Rezoning Transportation Analysis
Petition Number: Insert Zoning Petition #2021-209
General Location Identifier: 20109103

From: Jake Carpenter, PE
Jacob.carpenter@charlottenc.gov
980-221-5675

Date	Description
01-24-2022	First Review (KP)
03-21-2022	Second Review (KP)
12-28-2023	Third Review (DR)

1 REZONING PLAN

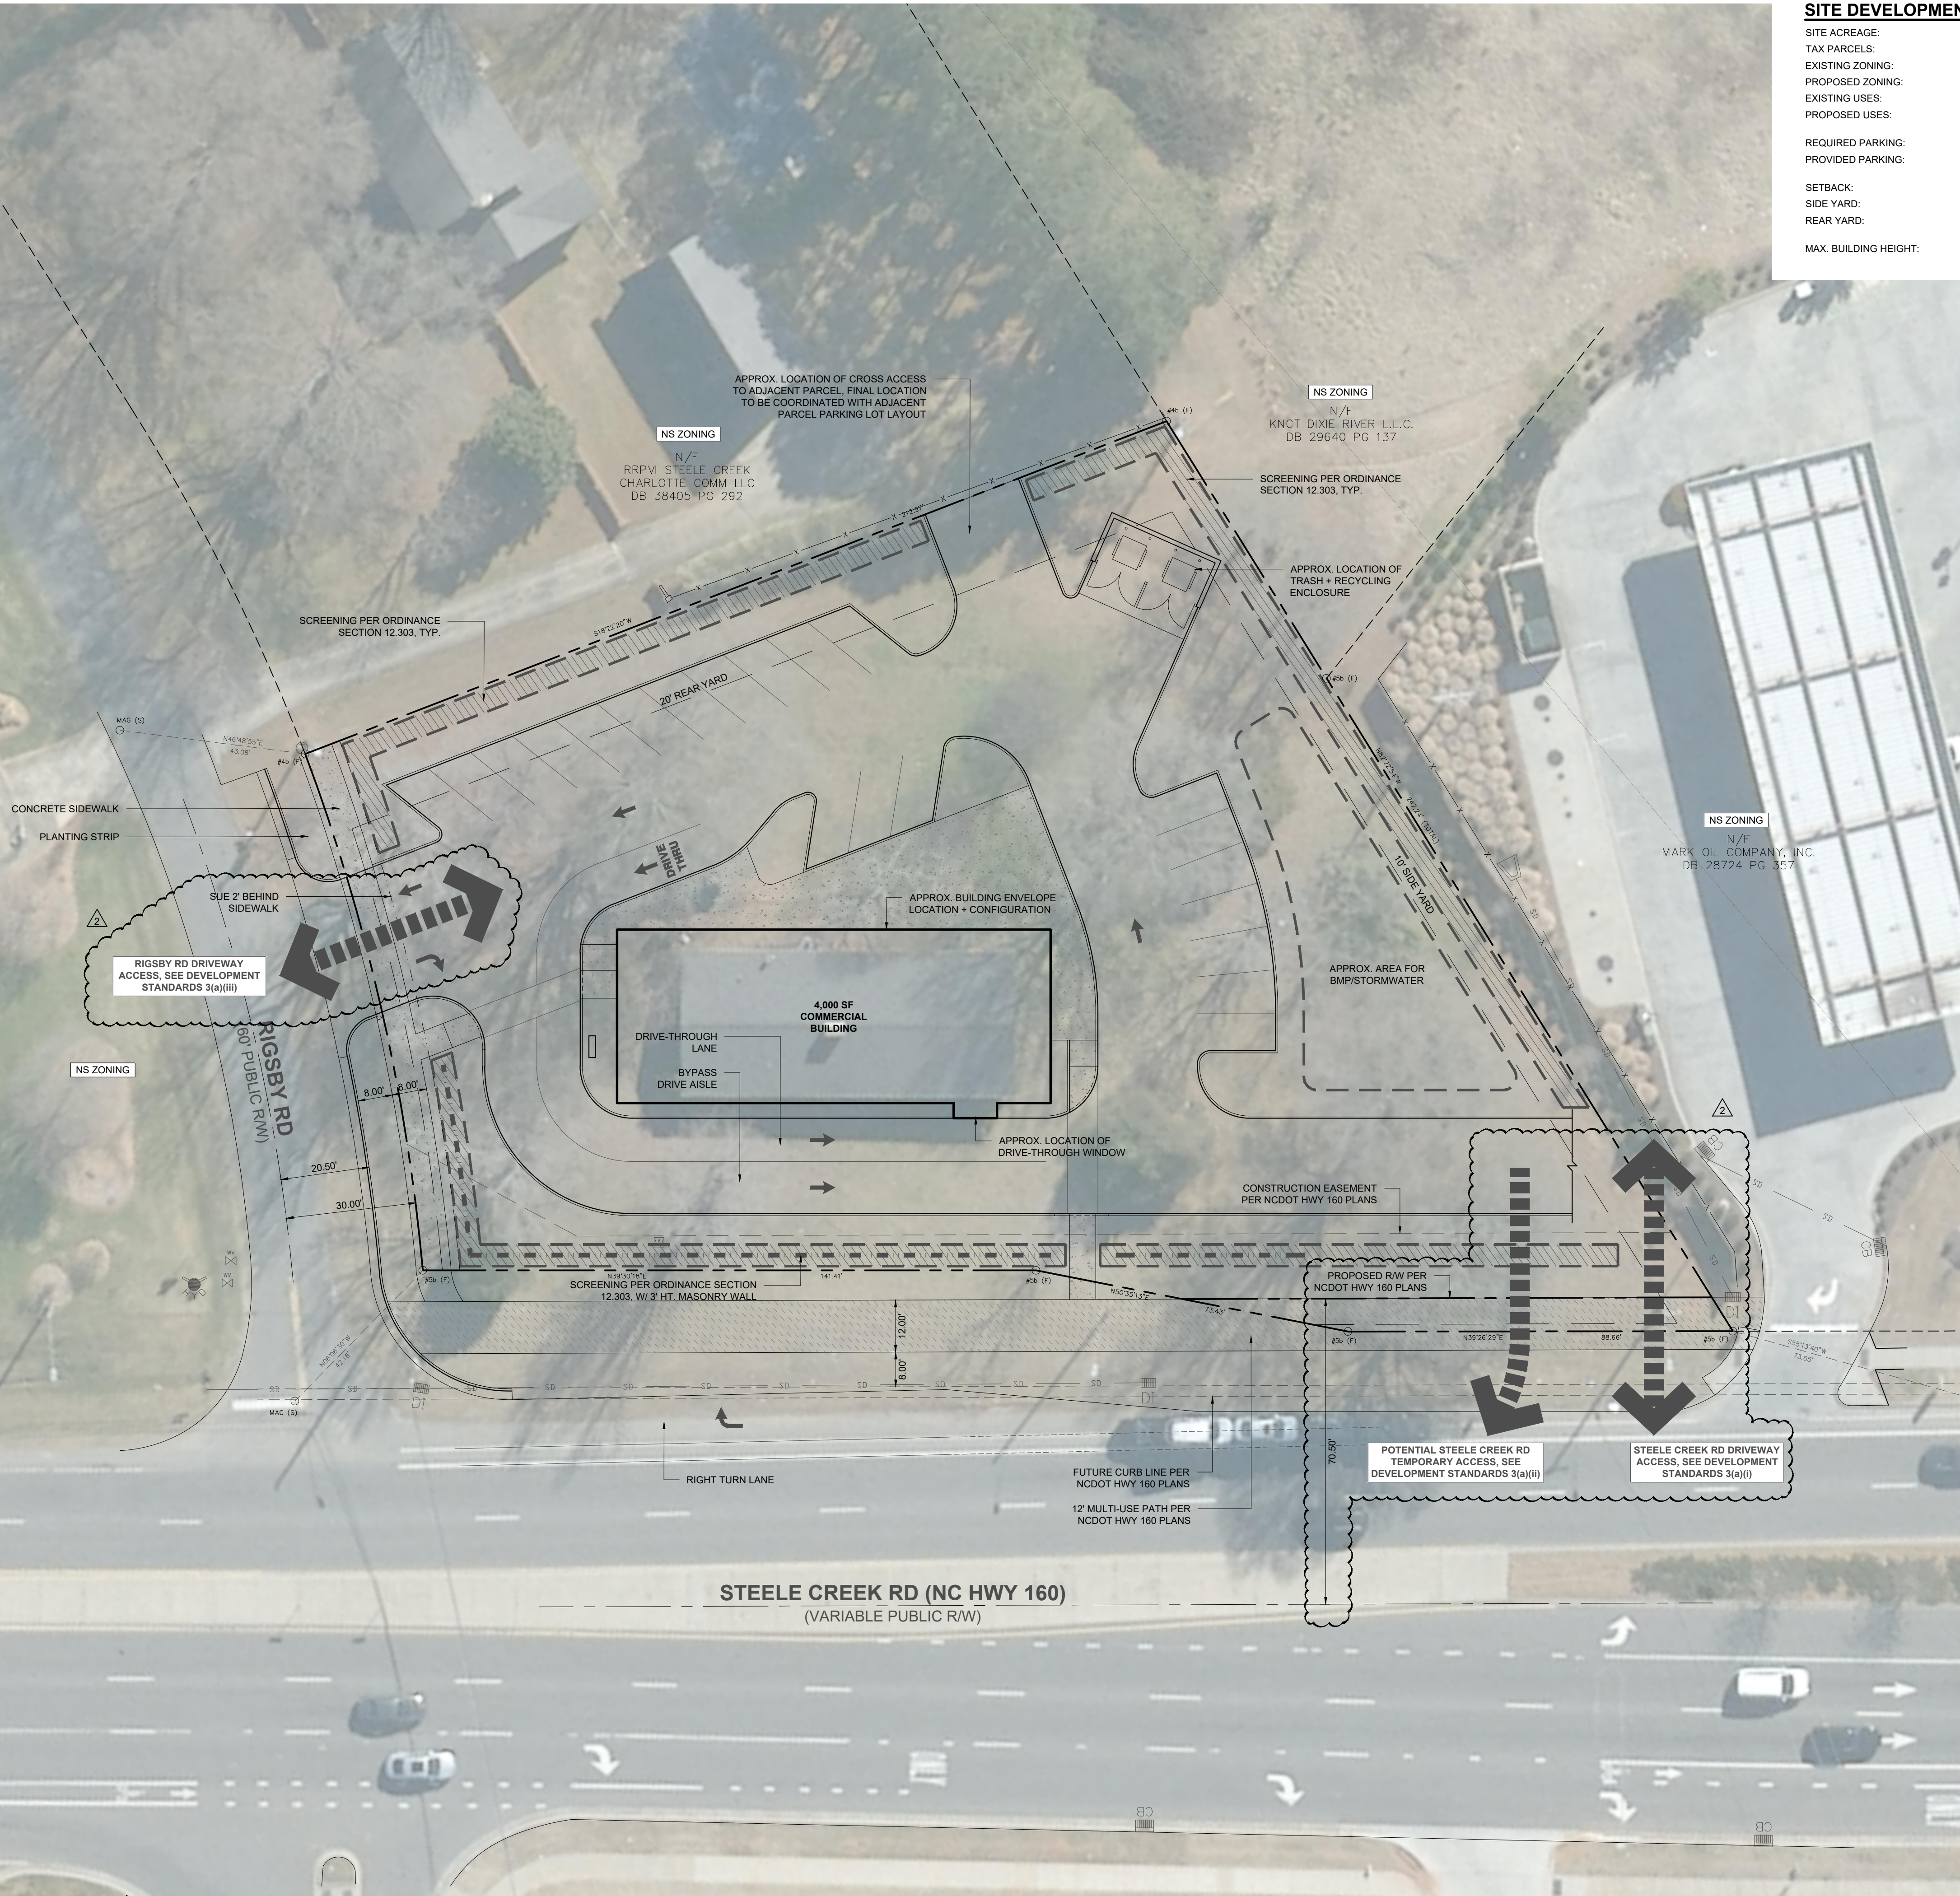
1. ~~**Curb line:** The proposed zoning district has a setback measured from back of the existing or proposed future curb line.~~
 - a. ~~**Steele Creek Road:** Curb and gutter will be constructed in accordance with the typical section established in the U-5766 STIP Project, as generally depicted on the site plan. Rescinded after 03/10/2022 Coordination with petitioner and NCDOT.~~

- b. ~~**Rigsby Road:** Curb and gutter will be constructed in accordance with CLDSM U-05A, Local Commercial Wide cross section with the back-of-curb located 20.5 feet from the existing centerline.~~

Label and dimension the back of curb and gutter from the existing centerline of each road.

- a. **Steele Creek Road:** ~~Revise site plan and conditional note(s) to commit to dedicate the right-of-way and easements, in accordance with the typical section established in the U-5766 STIP Project, as generally depicted as on the site plan.~~

- b. **Rigsby Road:** ~~Revise the site plan and conditional notes to dedicate 38.5 feet of right-of-way, in accordance with CLDSM U-05A Local Commercial Wide cross section, from the existing road centerline.~~

Outstanding Comment: ~~The site plan shall label and dimension the right-of-way from each road centerline.~~

- 4. ~~Revise site plan and conditional note(s) to commit to construct an 8-foot planting strip and 8-foot sidewalk along the site's frontage of Rigsby Road, in accordance with CLDSM U-05A, Local Commercial Wide cross section. The site plan shall label and dimension both items from the back of curb and gutter and road centerline.~~
- 5. ~~Revise site plan and conditional note(s) to commit to construct the 12-foot shared-use path along the site's frontage of Steele Creek Road, in accordance with the typical section established in the U-5766 STIP Project, as generally depicted on the site plan.~~

6. ~~Revise site plan by removing the proposed right in right out driveway on Steele Creek Road.~~

7. ~~Revise the site plan and conditional notes to commit to construct a northbound right turn lane, on Steele Creek Road, at Rigsby Road. The storage and taper lengths will be subject to NCDOT standards and approval.~~

9. ~~A site plan note(s) specifying dedication and fee simple conveyance of all rights of way to the City and NCDOT before the site's building certificate of occupancy is issued as needed. CDOT requests rights-of-way set at 2' behind back of sidewalk where feasible.~~
Update to Comment as a Result of 03-14-2022 Site Plan: Place a sidewalk utility easement 2-feet behind the sidewalk along Rigsby Road.

- 12. ~~New Comment as a Result of 03-14-2022 Site Plan: Revise the conditional notes by committing to provide an access easement, during permitting, with PID 20109114 to allow cross-access as generally shown on the site plan.~~

- 13. ~~New Comment as a Result of 03-14-2022 Site Plan: Revise the site plan by clarifying the 6-foot dimension on the site's frontage of Steele Creek Road.~~
